Subject: RE: K/17/22/PL

I'm writing in connection to this planning application that I now believe has 'conditional approval'.

PROPOSED EAST ELEVATION 1:100

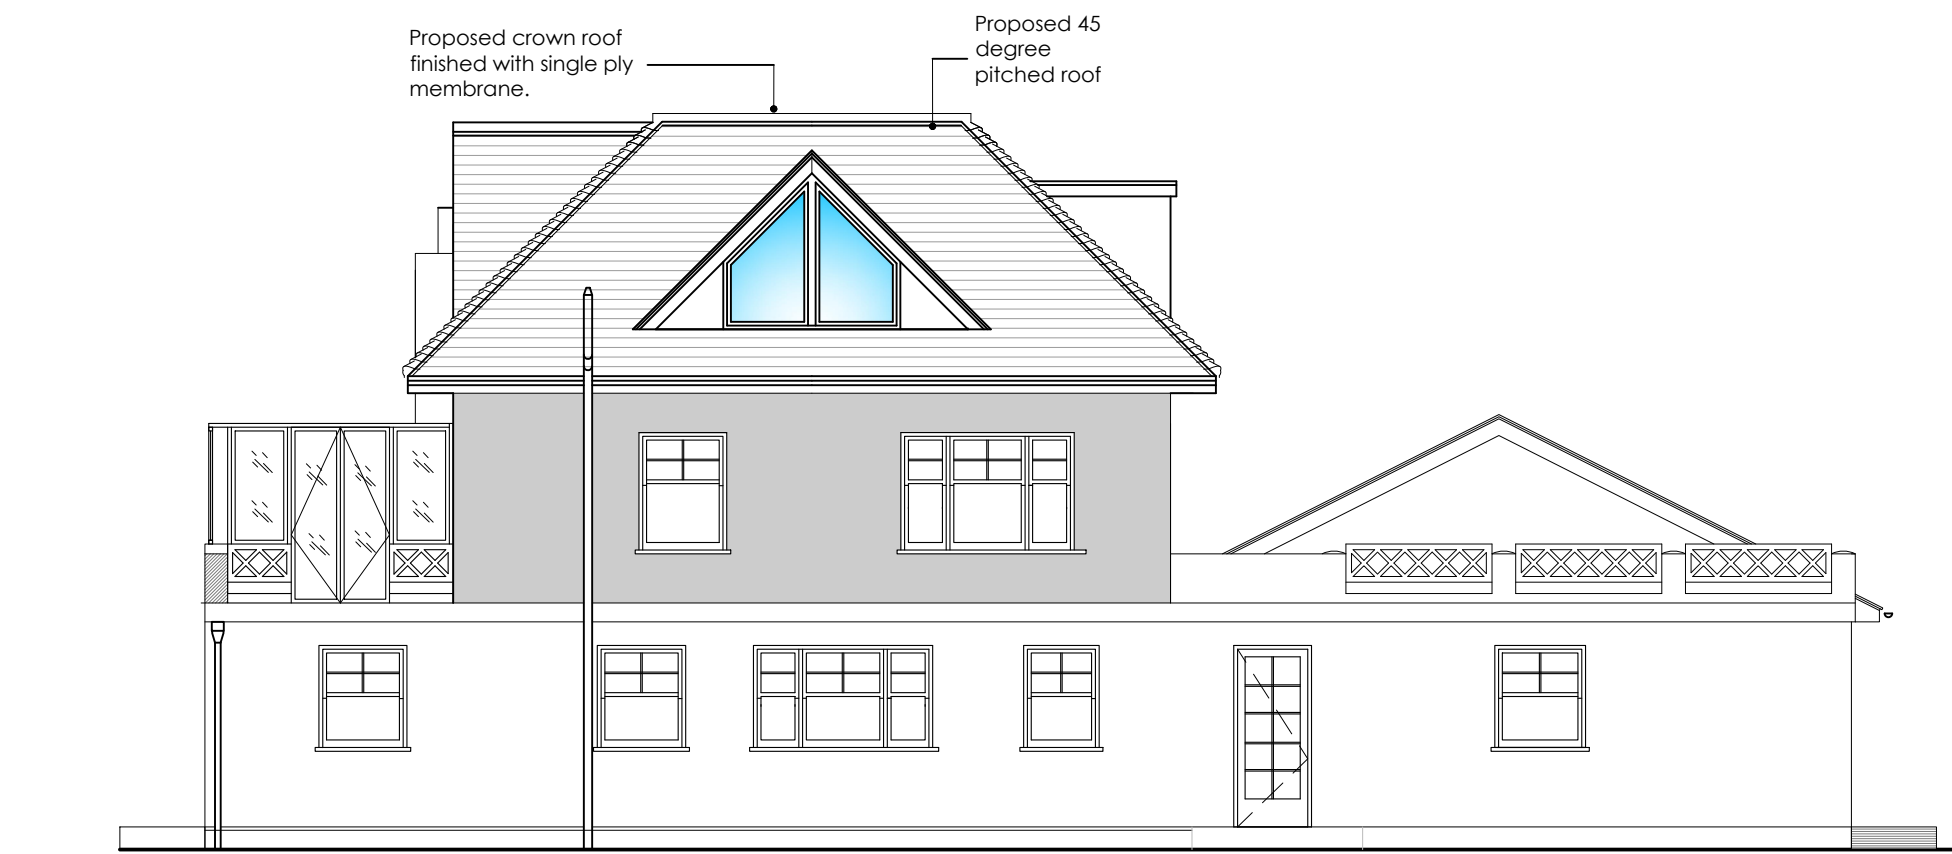
I would like to please request that the East Facing windows have mandatory privacy glass.

As stated in my objection comments, if this build goes forward, these windows will look directly into the bedrooms of my property on 69 Coastal Road, BN16 1SW, because of the additional floor proposed.

Thank you for your email, I believe you should now be able to view the decision notice on the ADC website. There are conditions imposed relating to obscure glazing.
